Item No. **Report of the Head of Planning, Transportation and Regeneration**

Address LAND AT CHARVILLE LANE ESTATE CHARVILLE LANE HAYES

Development: Installation of an 18 metre high, monopole tower, associated radio-equipment cabinets including one that will wrap around the base of the mast, and ancillary development hitherto (Application under Class A, Part 16 of Schedule 2 to the Town and Country Planning (General Permitted Development) (England) Order 2015 (as amended) for determination as to whether prior approval is required for siting and appearance).

LBH Ref Nos: **76859/APP/2021/4183**

Title:
265 PROPOSED SITE ELEVATION

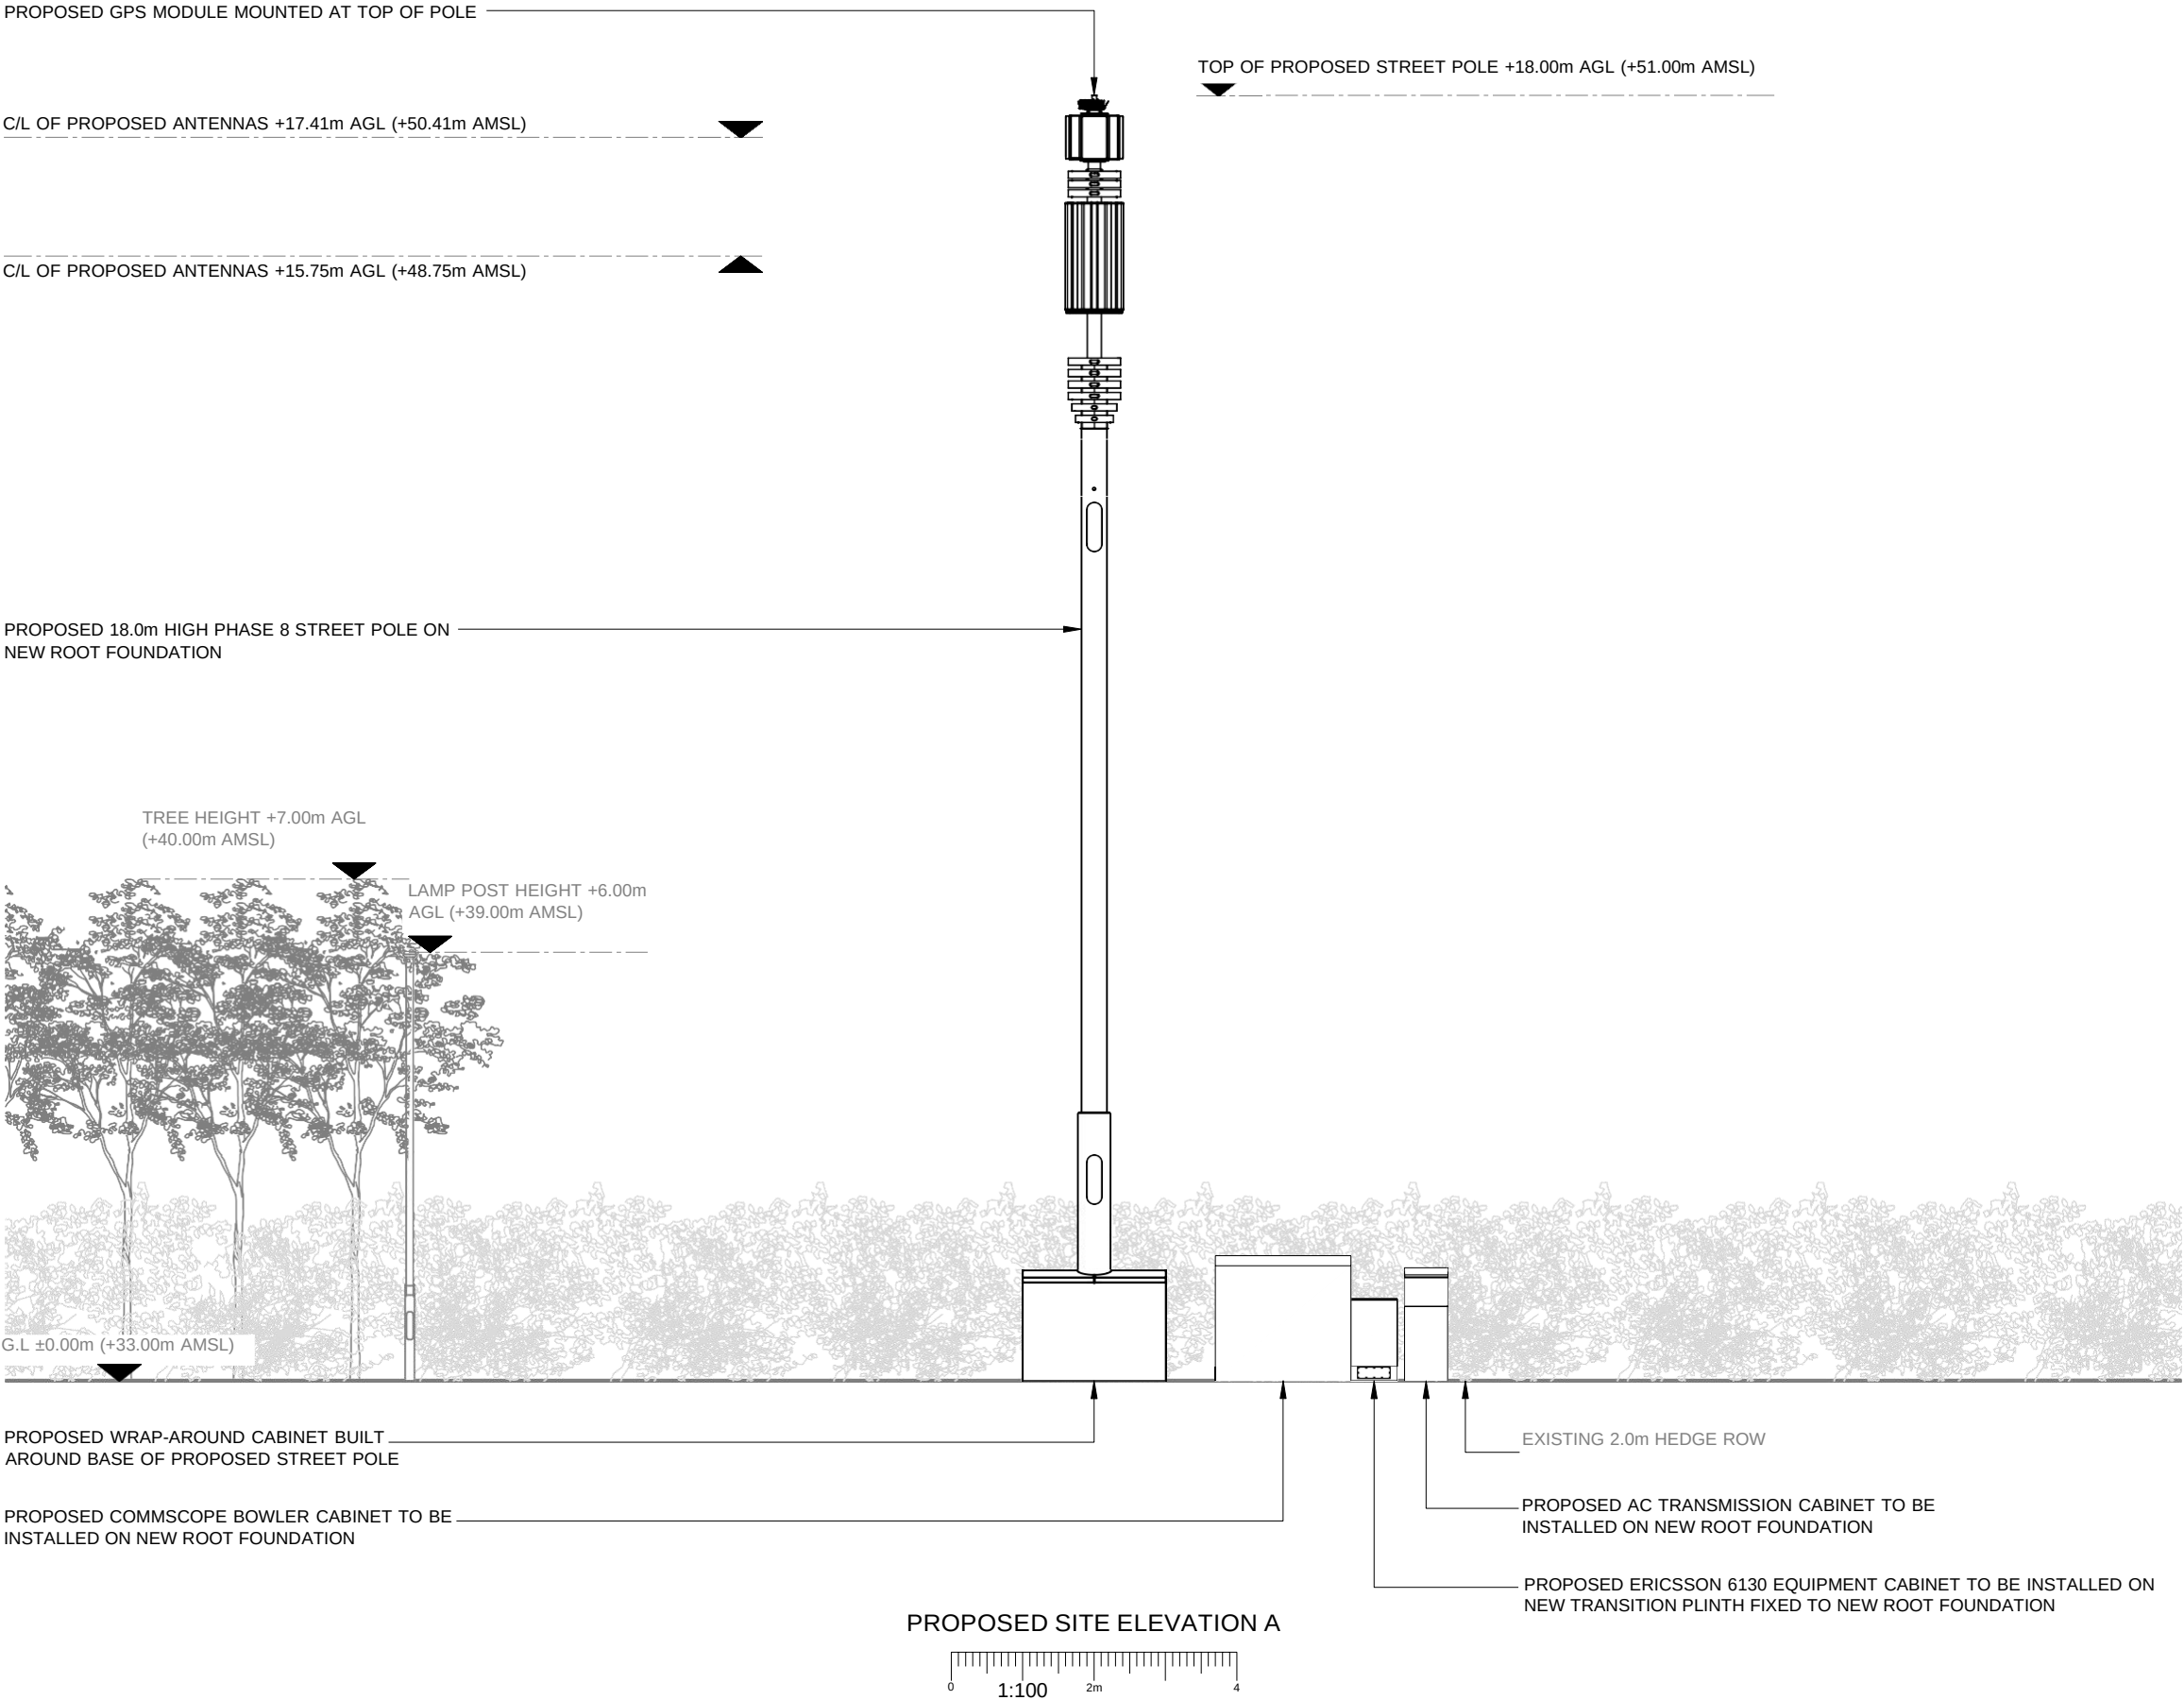
With a height of 18 metres, the proposed monopole would be significantly taller than the current street furniture (including 6m high street light poles) which are small in scale, spaced out and blend into the wider setting. There would also be 4 cabinets at ground level, including one that wraps around the proposed monopole.

The base of the monopole would be approx. 2m metres wide and 1.3m deep, and its top apparatus would have a diameter of approx. 0.6 metres. This again, would be considerably greater than the nearby lamppost poles. This would be a significantly bulky and dominating addition within the subject parcel of land.

The site is within a very prominent location to which the proposed monopole, by reason of its general siting (as proposed), combined height, width and depth alongside its scale, bulk and overall design would result in an imposing, dominating, incongruous, overbearing and visually intrusive addition that would negatively impact the character and appearance of the area.

In terms of the materials, it is proposed to have a steel colour grey finish to replicate similar lamp posts of the context. The cabinets would be finished in a green colour. The materials and colours to be similar of nearby street furniture (which are smaller) would not mitigate the impact the proposal would have to the character and appearance of the surrounding area, in terms of its height, scale, siting, size and bulk.
